MP09_0146 – Mixed use development at Eastlakes Shopping Centre

Brian Mander
Bus Operations Manager

3.1 urban design principles site circulation

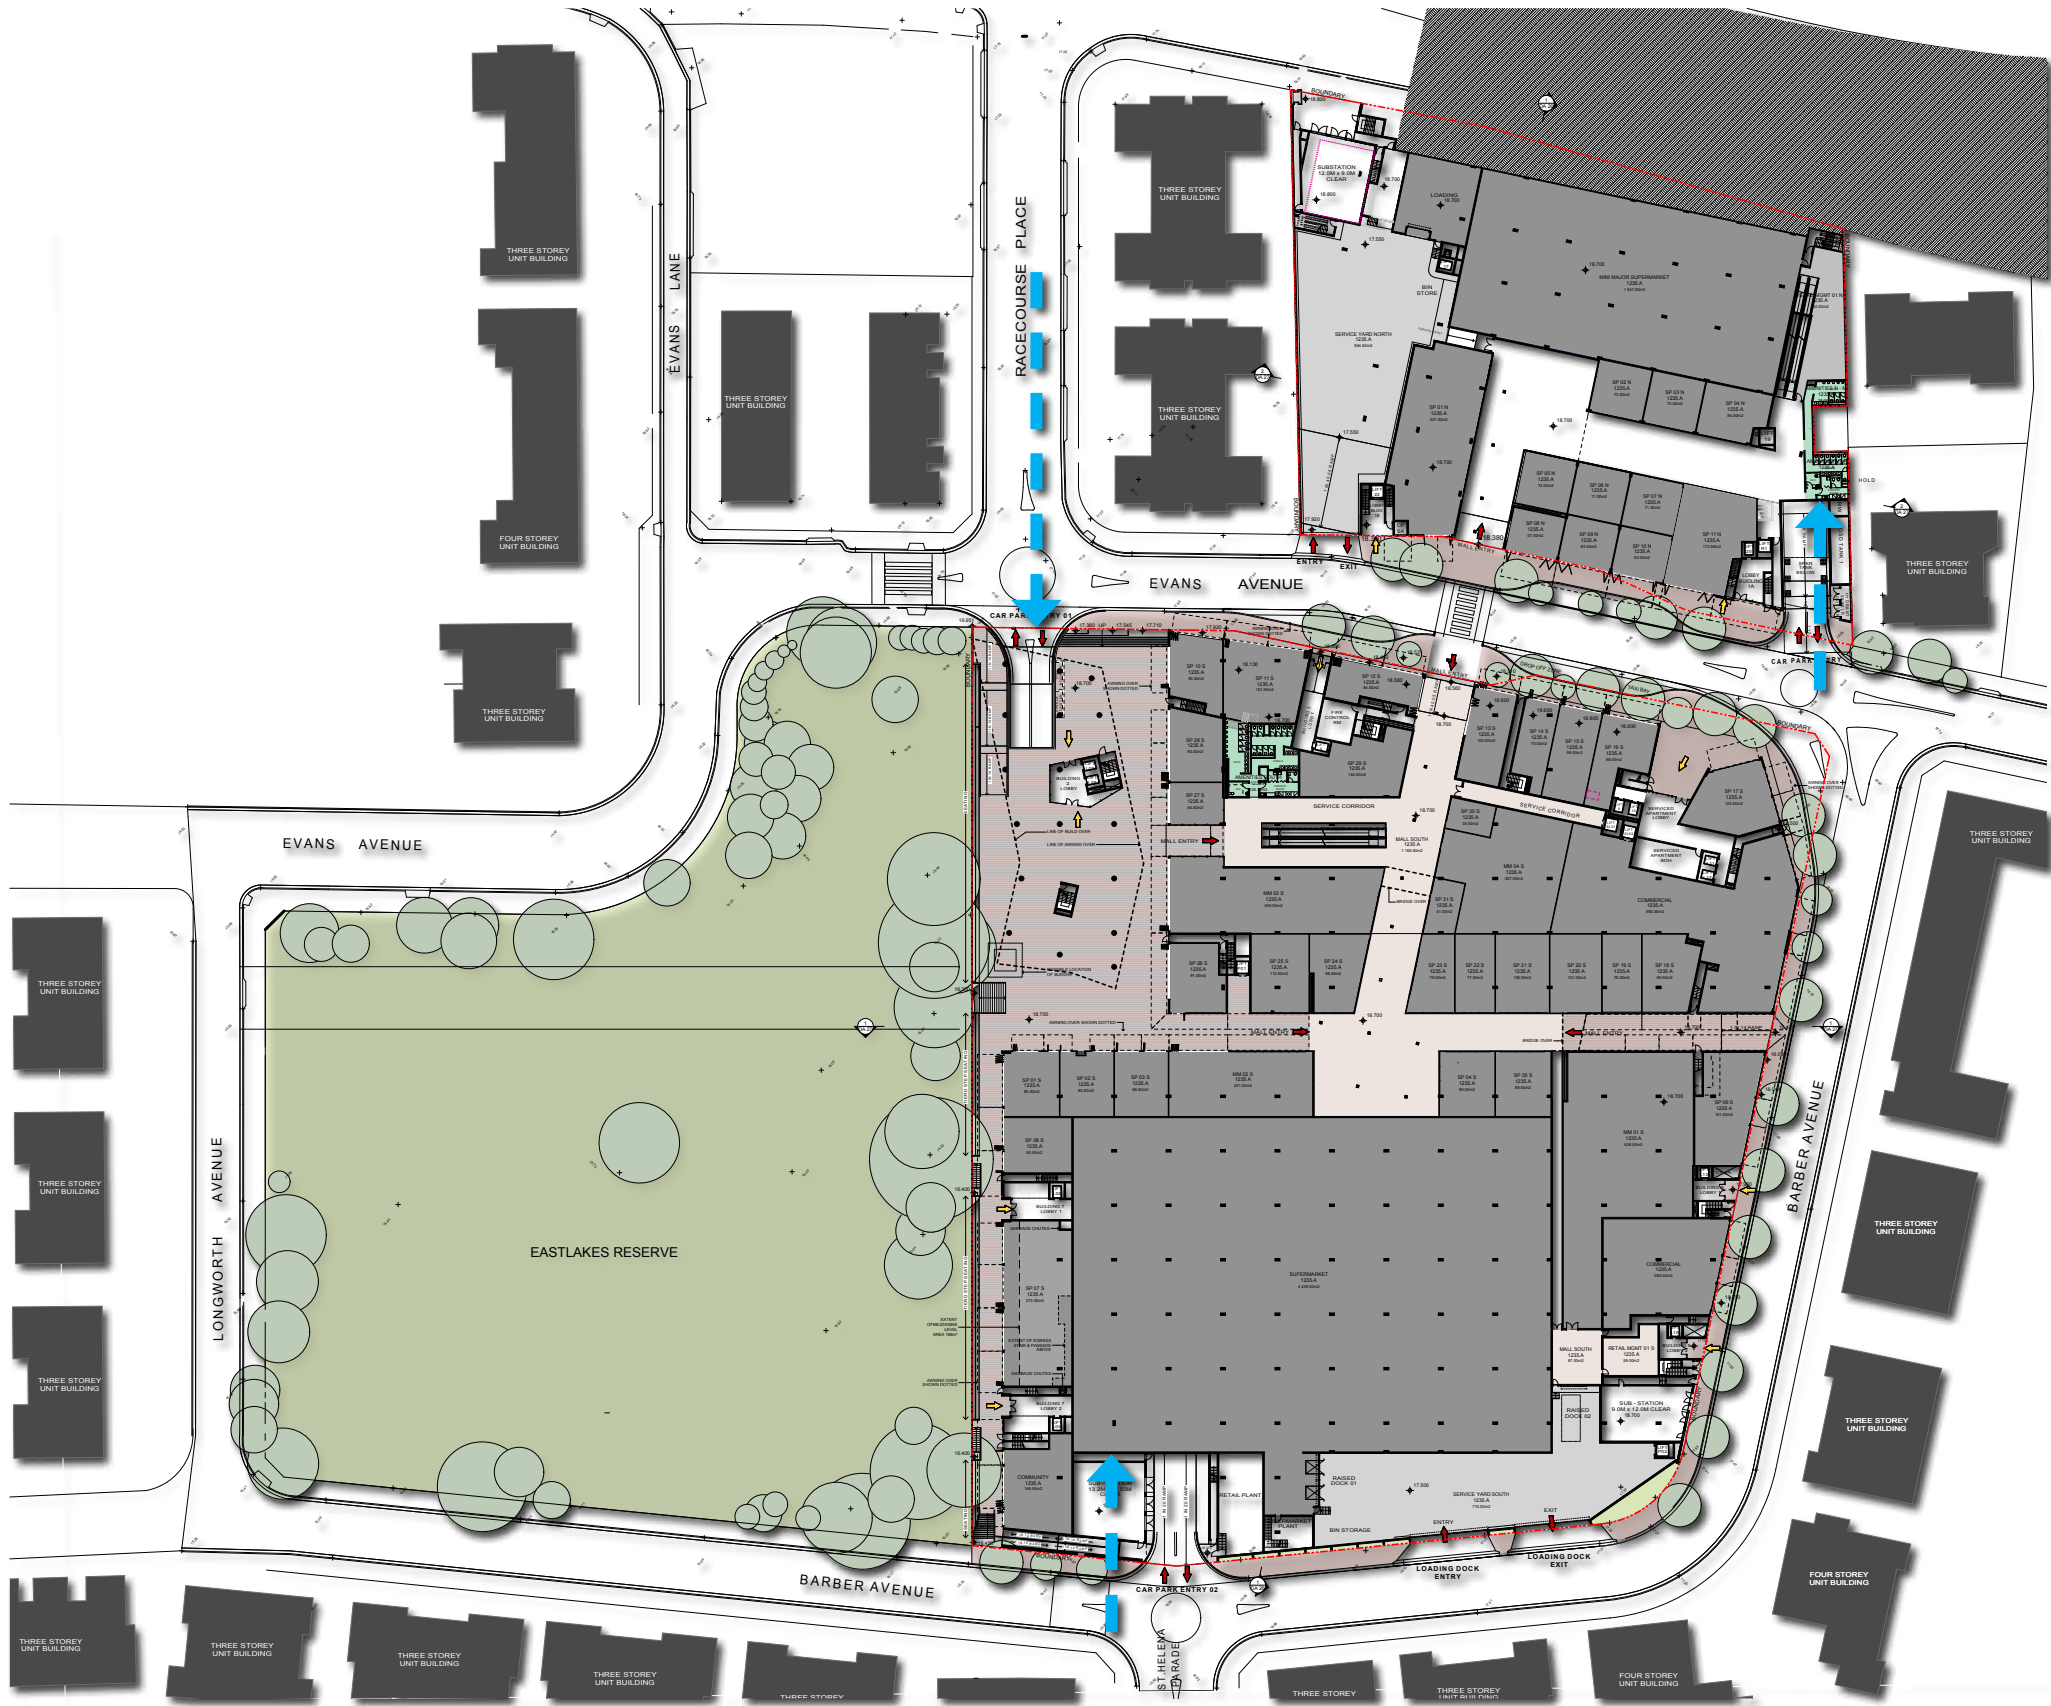
1. Roundabout treatment at the intersection of Evans Avenue and Racecourse Place. The proposal is to construct a mountable roundabout at this intersection with a two lane egress from the development. Sydney Buses routes 301 and 303 operate through this intersection. We have some concerns that a two lane discharge reduces sight lines at the intersection and may create a conflict point between buses turning and mounting the roundabout and vehicles leaving the car park. We request that a road safety assessment be undertaken for the proposed two lane egress to identify potential safety problems.

If the road safety assessment determines that a roundabout is the most suitable control for this intersection then the design of the roundabout should comply with the State Transit Bus Infrastructure Guide.
